CITY OF PORTLAND BUILDING PERMIT

PERMIT ID: 2012-65593

RE: Building Permit Application – Portland Community Health Clinic Renovations,
180 Park Avenue, Portland, Maine

Portland Community
Health Clinic- Renovation
Project

180 Park Avenue
 Portland, Maine

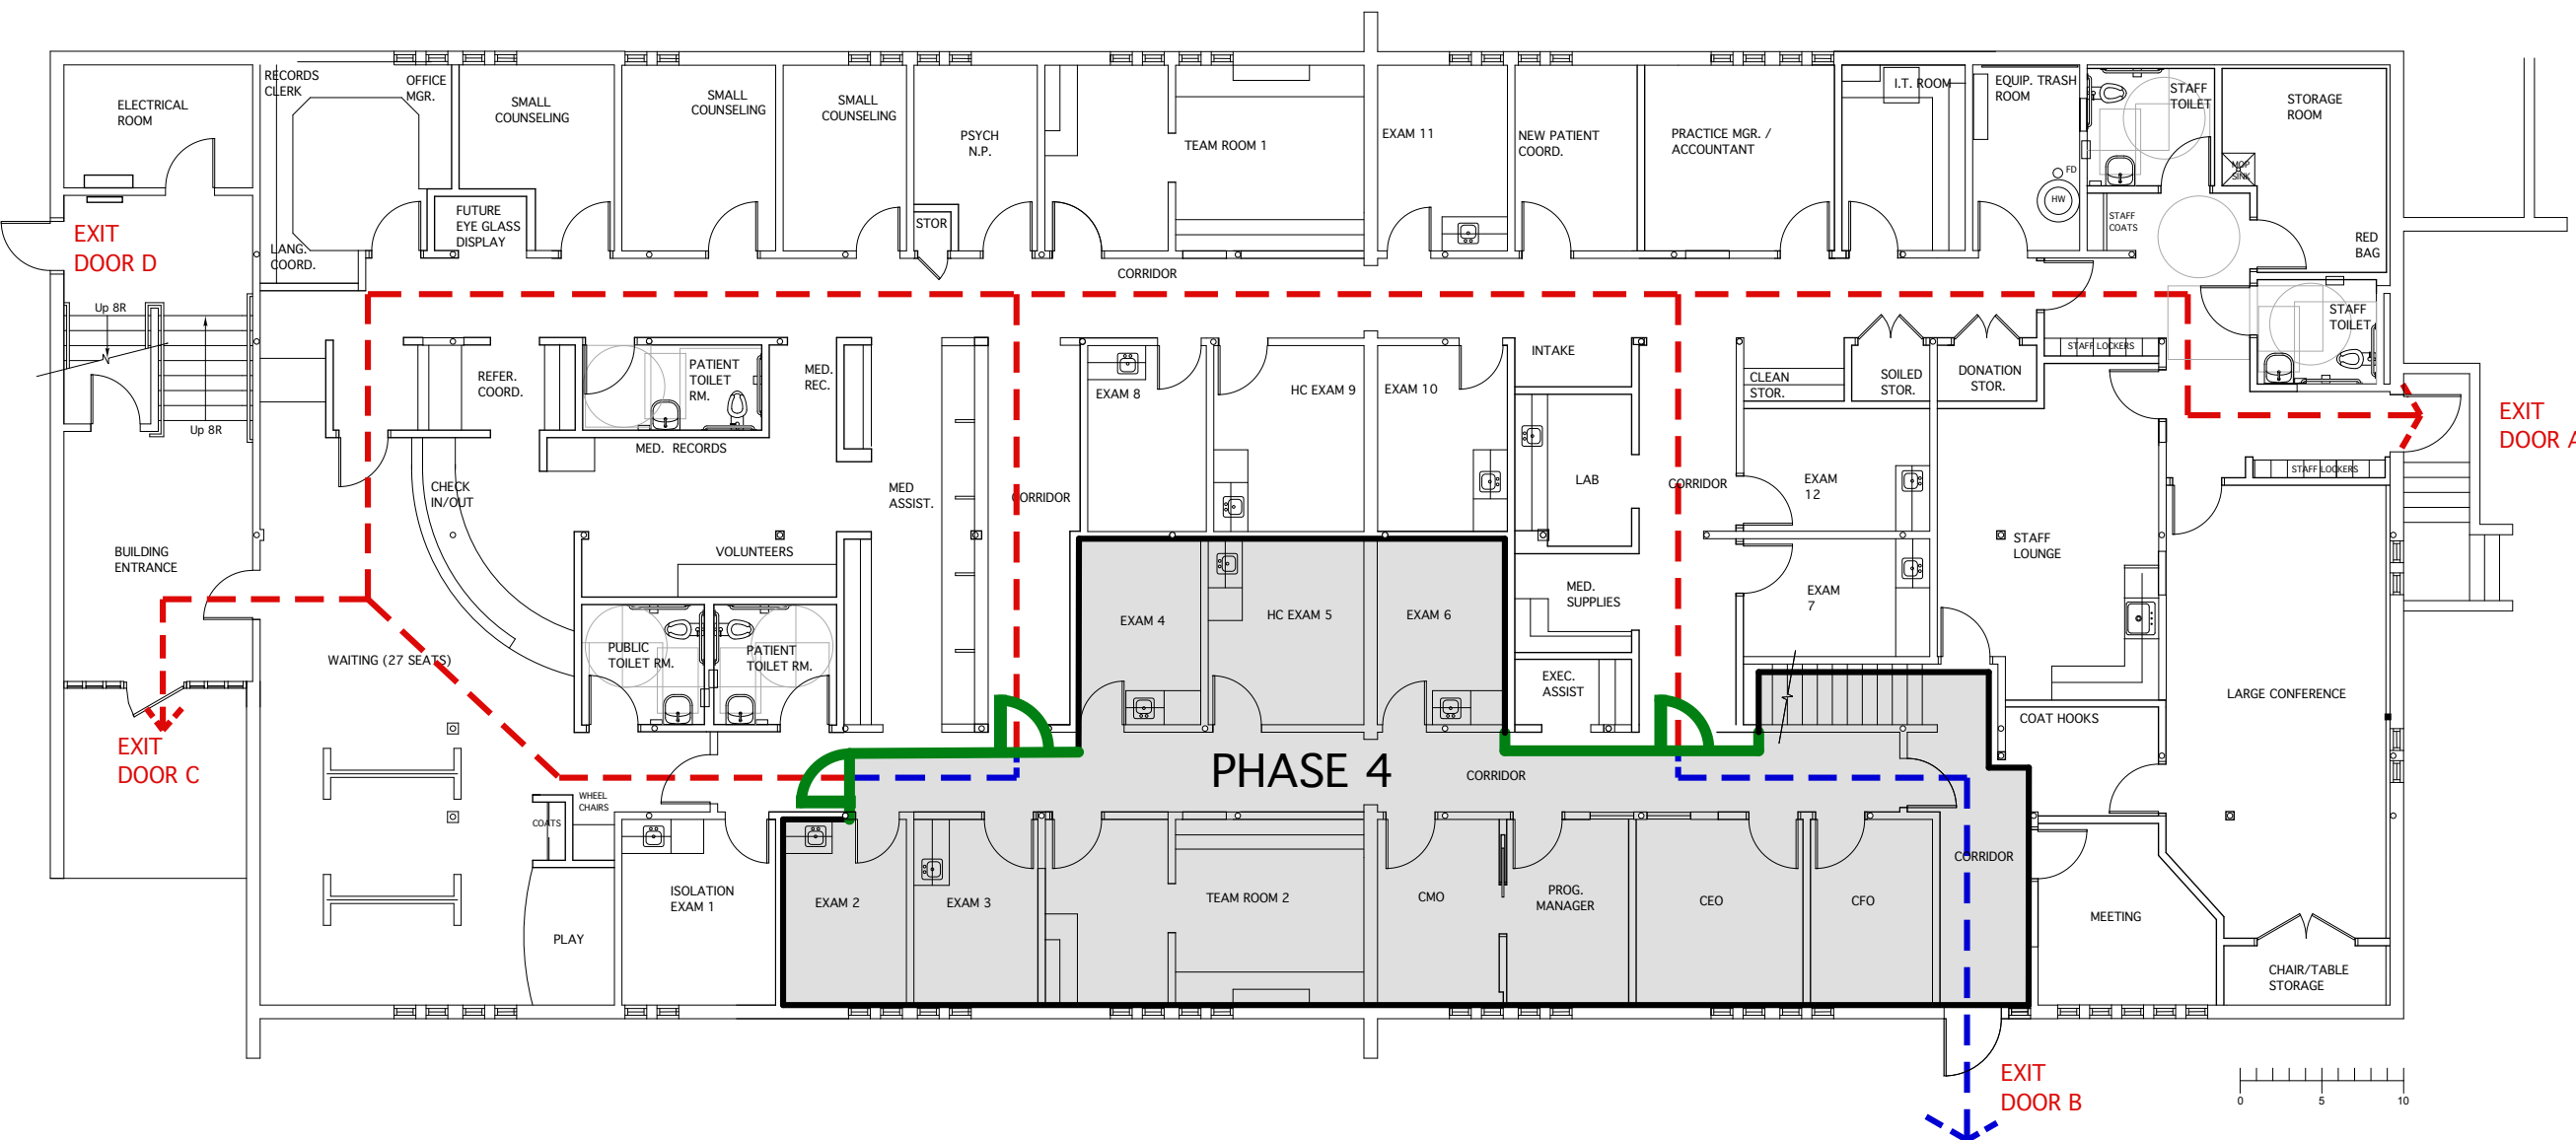
As discussed I have put together a series of phasing/exiting plans that show proposed exit paths during construction. The excessive dead end corridors you noted in your review can only be avoided by adding doors (signed as emergency exits) in the temporary partitions that would allow exit paths to traverse the construction areas.

While having people have to exit through the construction areas is not ideal, I have tried to locate the paths in areas of low impact construction. Our plan would be to instruct the contractor that he needs to keep the exit paths clear and signed so that the path to the exit door is clear and understandable to building occupants. We will also review interim exiting plans with the staff so everyone is made aware of the adjusted paths to exits at each phase.

These through construction alternate route egresses are acceptable per IBC Sec. 3302, considering the phasing schedule and desired occupancy of the space. As you have summarized, clarity in these areas should be of high priority, closely monitored, and instructed to the occupants.
